FINAL DRAINAGE LETTER FOR LOT 6 OF CLAREMONT BUSINESS PARK 2 FILING NO. 1

EL PASO COUNTY, COLORADO

MARCH 2021

Project #44-037
PCD – SP 20-000

### PROPOSED DRAINAGE MAP - LOT 6

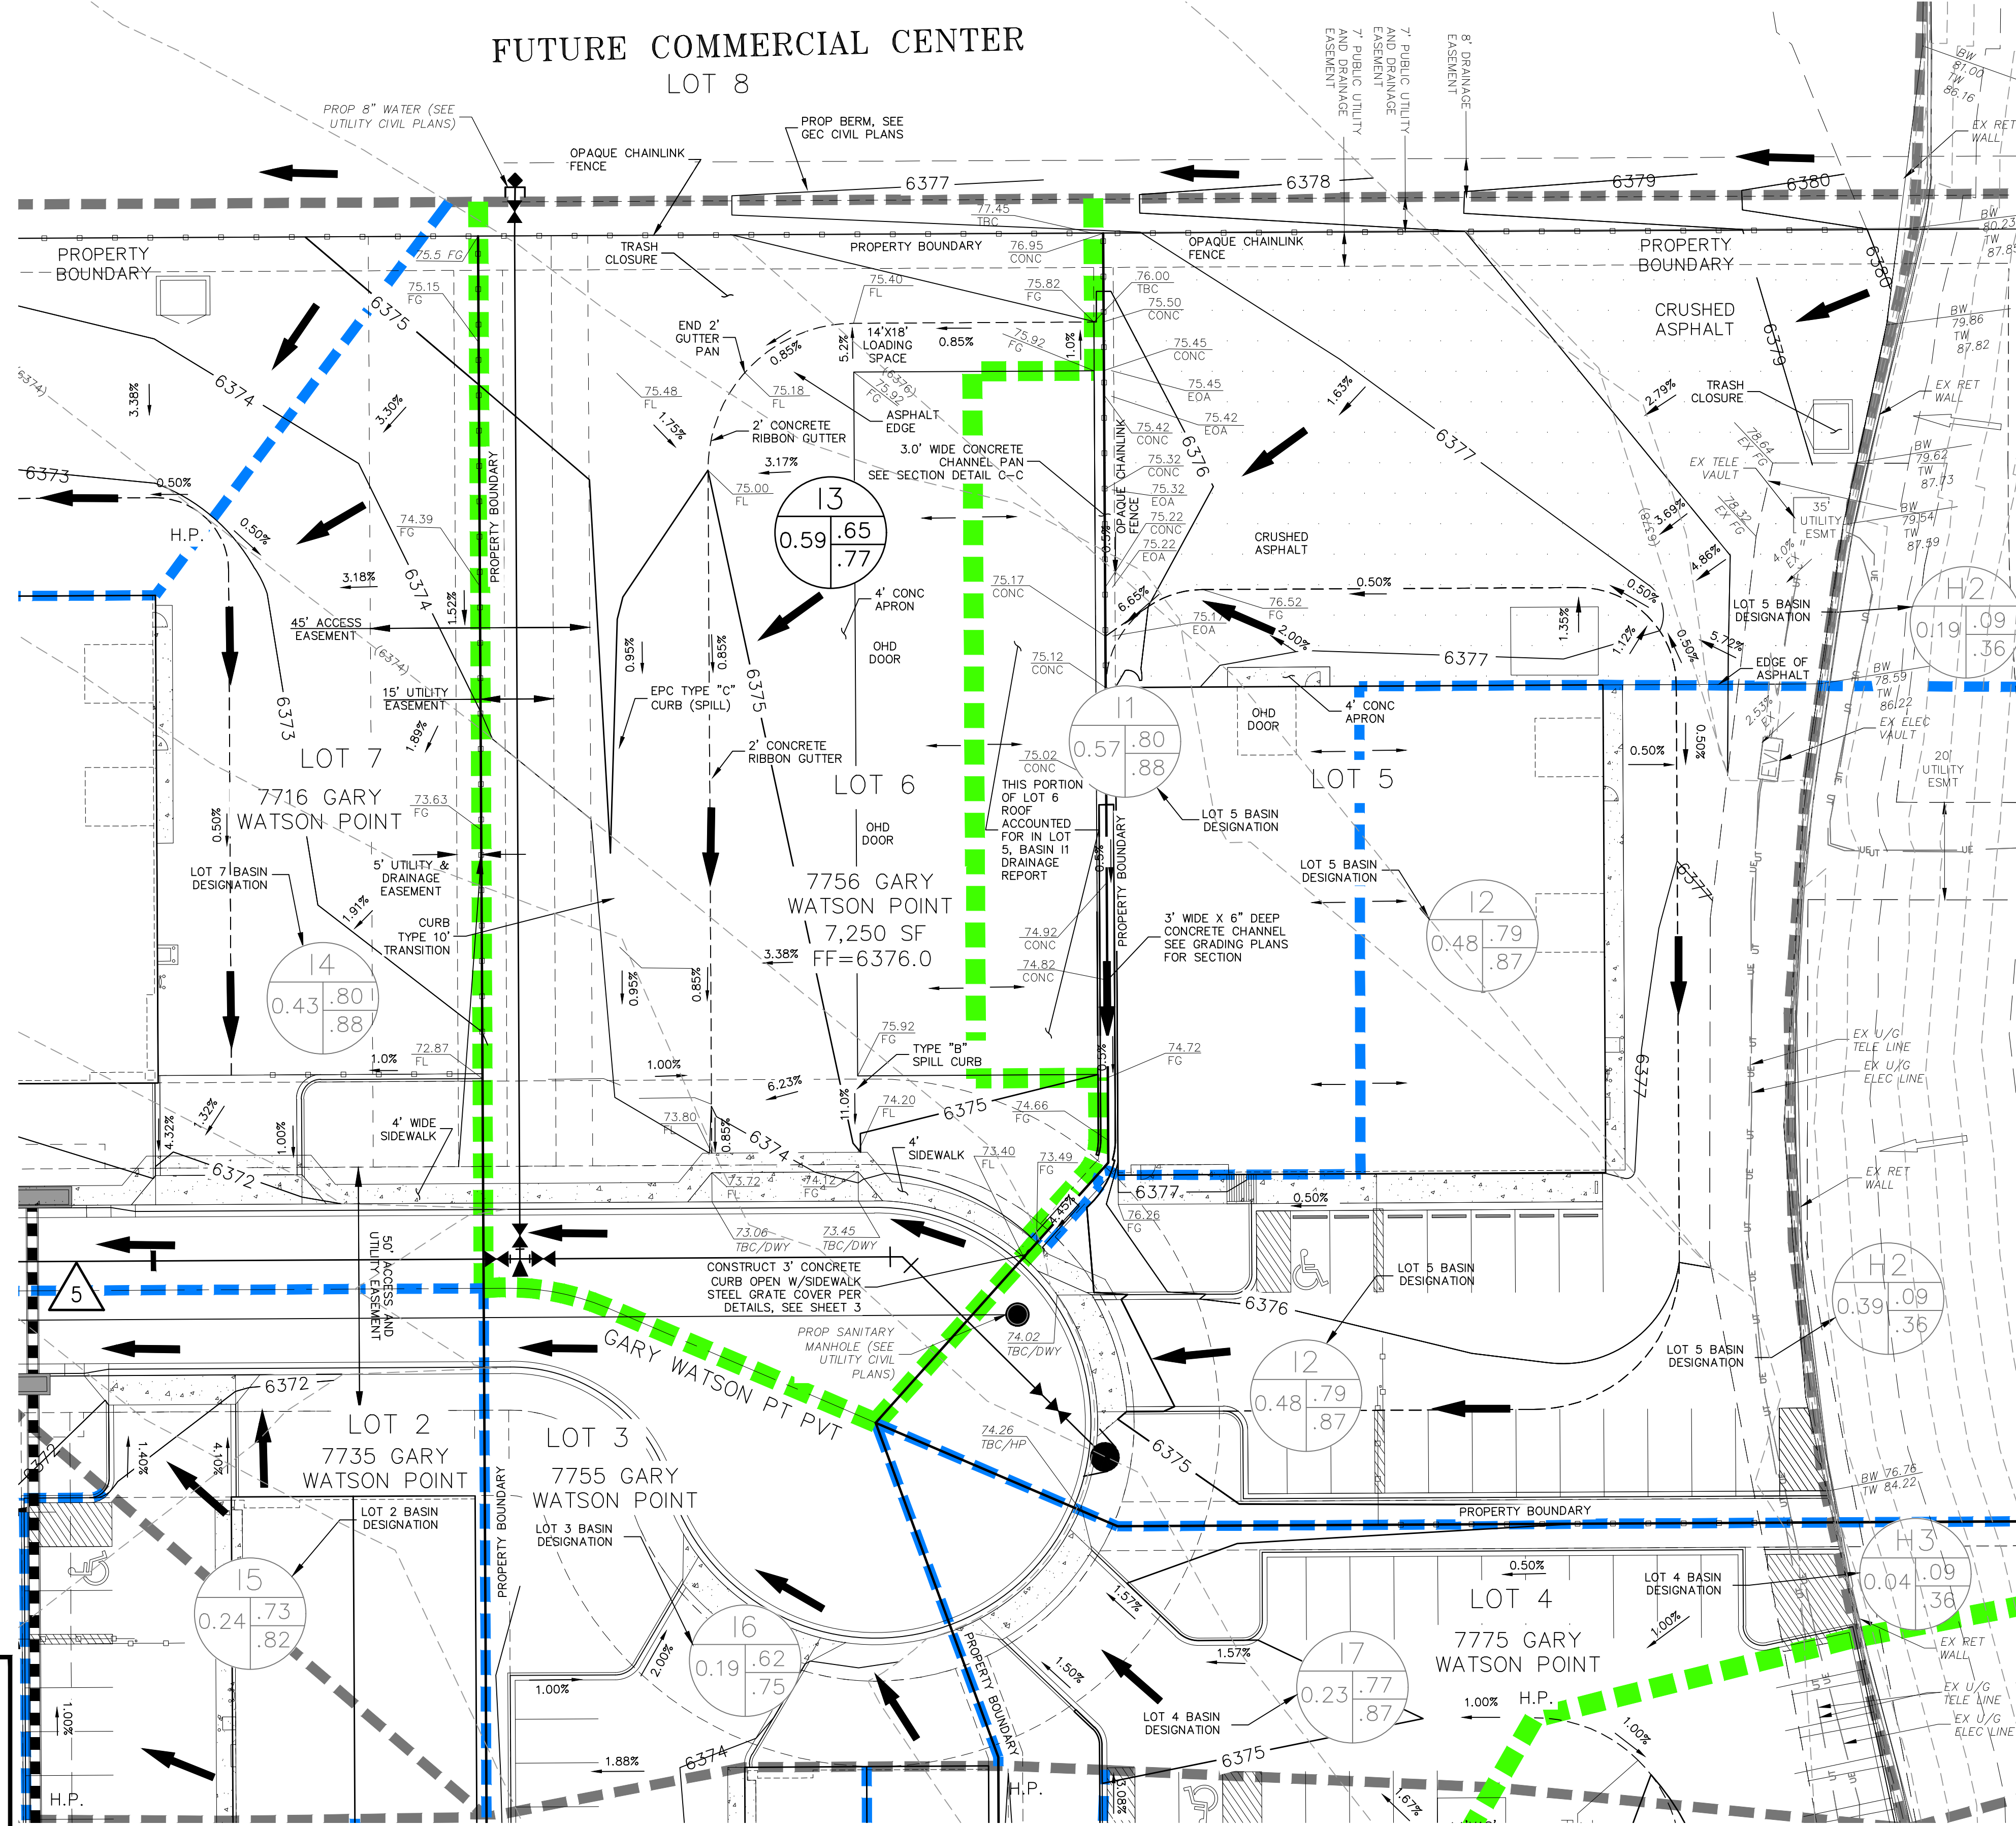
Per lot 5 drainage map and flow arrows runoff from lot 5 drains through lot 6 basin. Update runoff values to show cumulative runoff quantities at design point 1.
